**WELWYN HATFIELD BOROUGH COUNCIL
ASSISTANT DIRECTOR (PLANNING)**

DELEGATED APPLICATION

Application No: 6/2023/2244/LB
Location: Northaw House Coopers Lane Northaw Potters Bar EN6 4NG
Proposal: Replacement of 6 ground floor windows within the northern elevation of Northaw House
Officer: Mr William Myers

Recommendation: Refused

Proposed Joinery Details

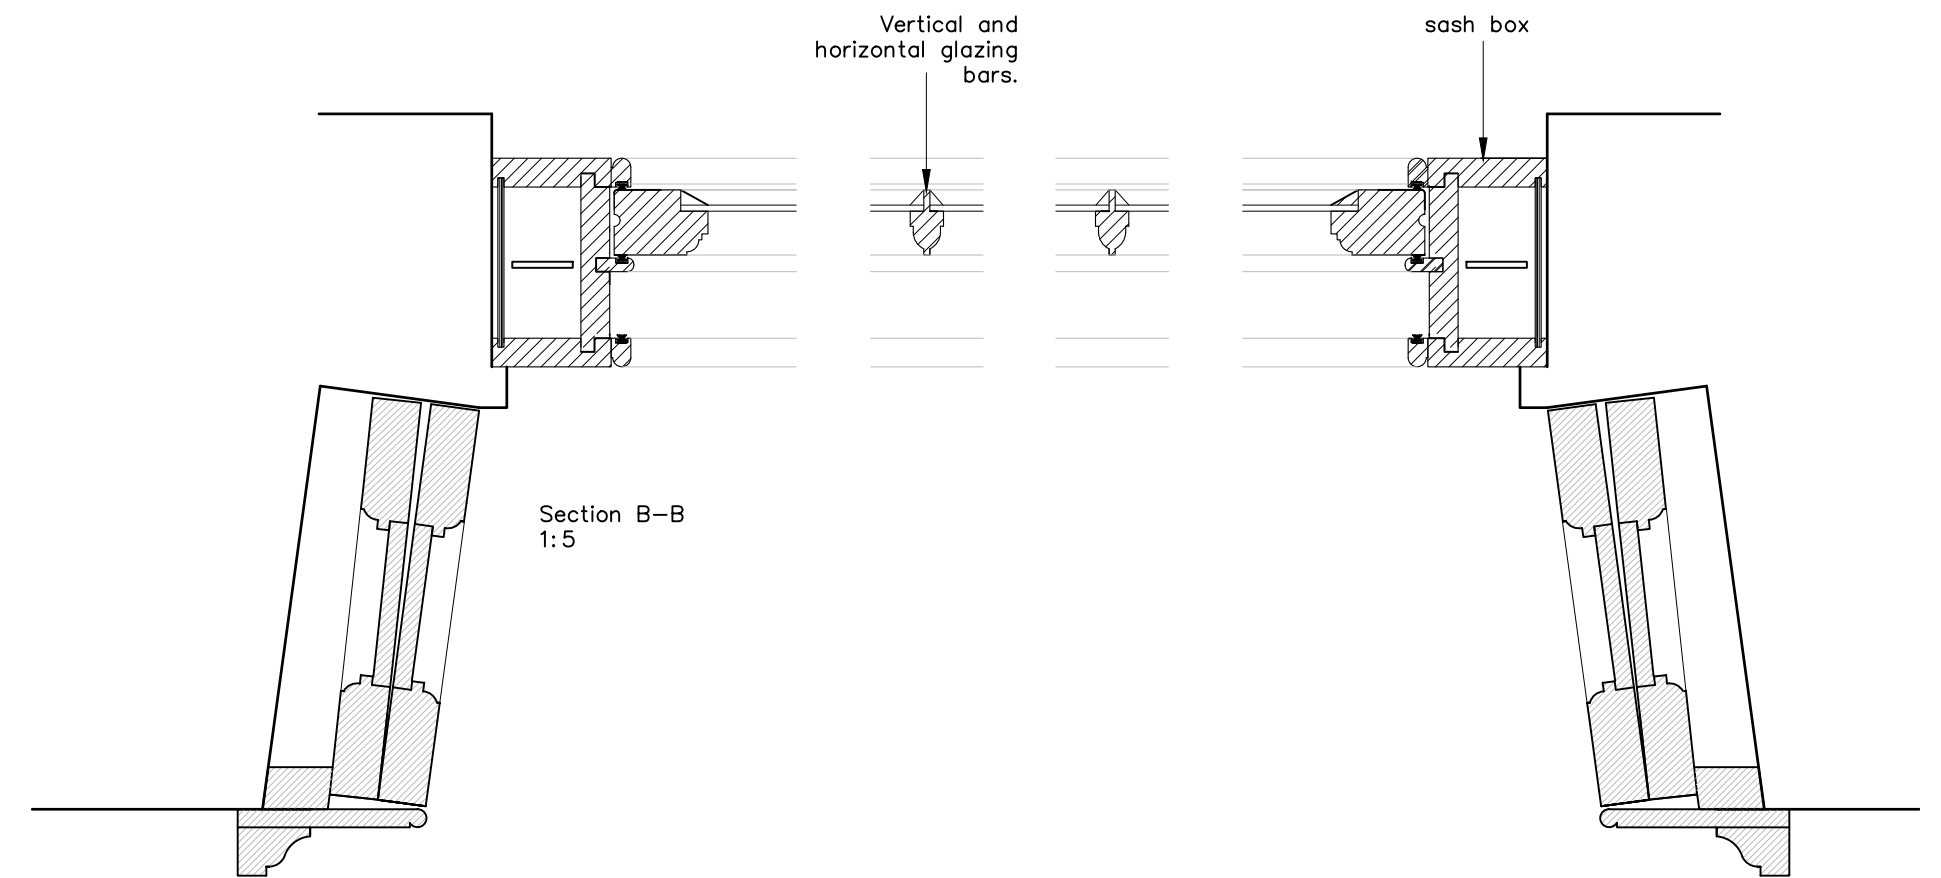
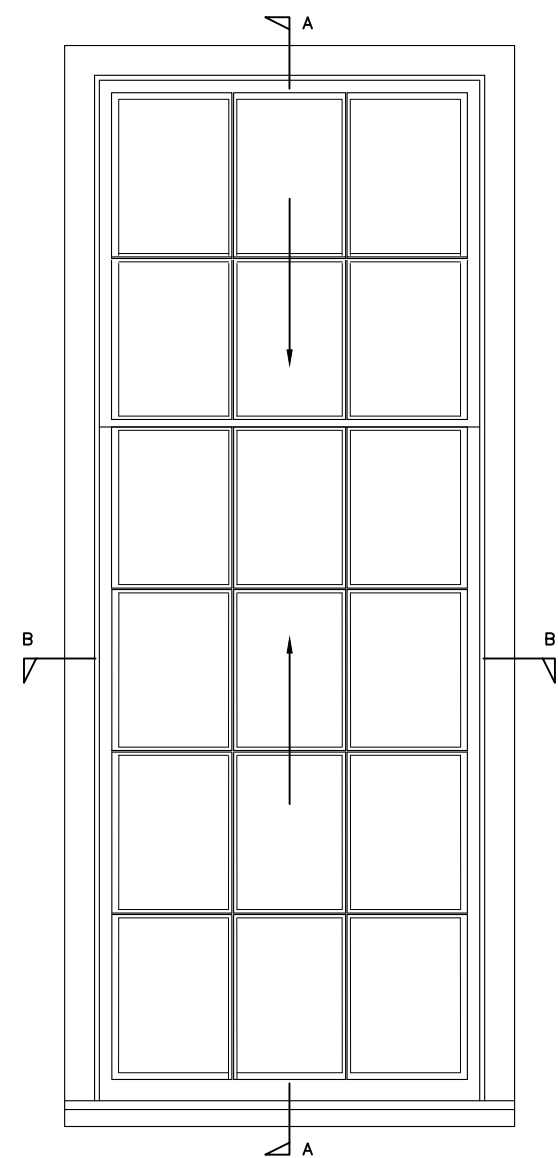
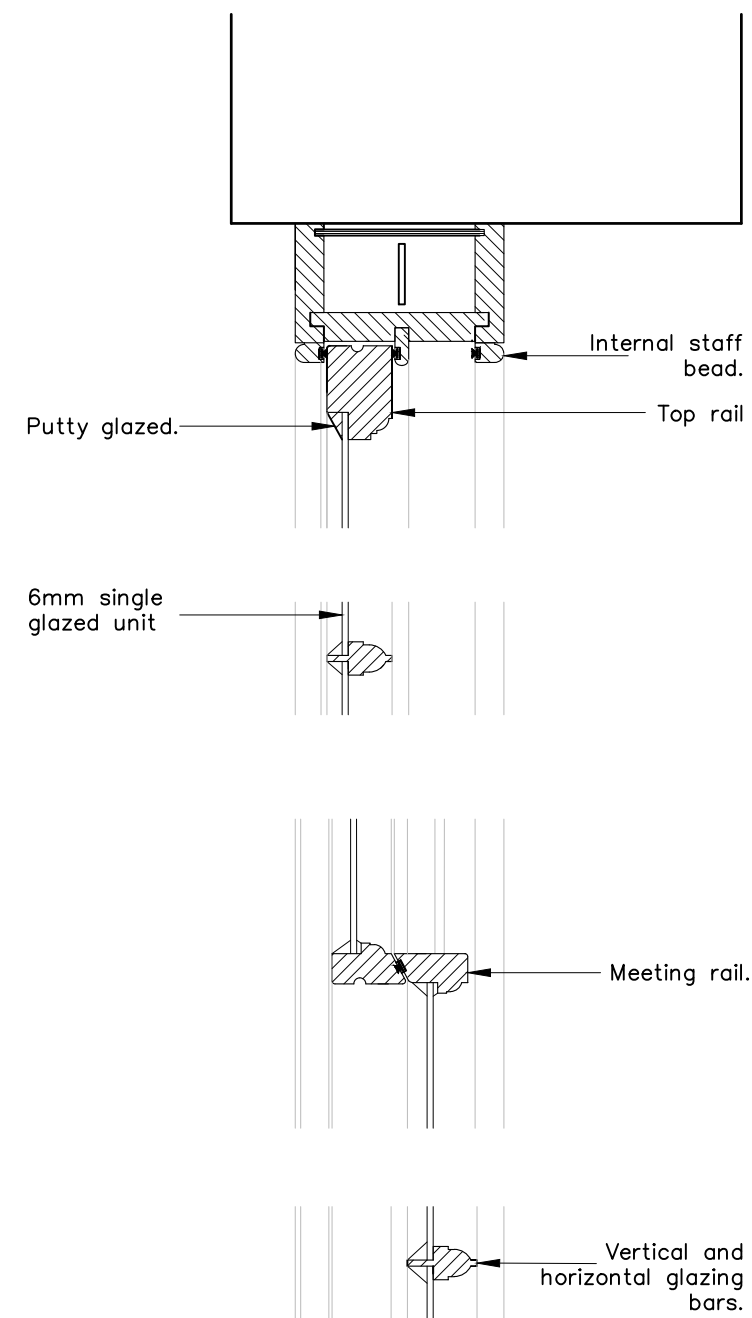
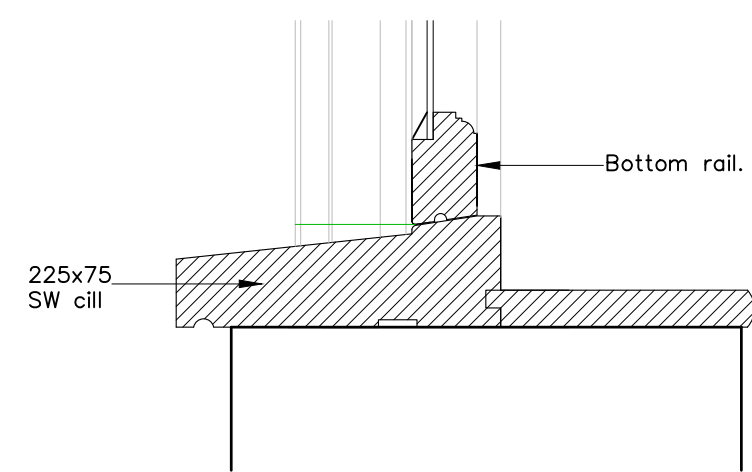
Removing the existing windows at ground floor and replacing them with sash windows would create a false arrangement. Whilst there may have been sash windows at some point, it is clear from the evidence, that this was before the later extensions and alterations. The sash windows on the northern elevation may have never existed alongside the subsequent eighteenth/ early nineteenth century extensions; Reinstating an earlier window design would create a potentially inaccurate composition that never existed. This would detract from the architectural and archaeological interest of the listed building.

Taking the above into consideration, even if the existing windows do not date from the early nineteenth century and are later replacements, they accurately follow the pattern and design of those seen in the 1805 engraving, therefore making a positive contribution to the significance of the listed building. The proposal would result in the complete loss of these windows which are considered to be positive, and the replacement windows would not be accurate copies. This would detract from the architectural and archaeological significance of the listed building.
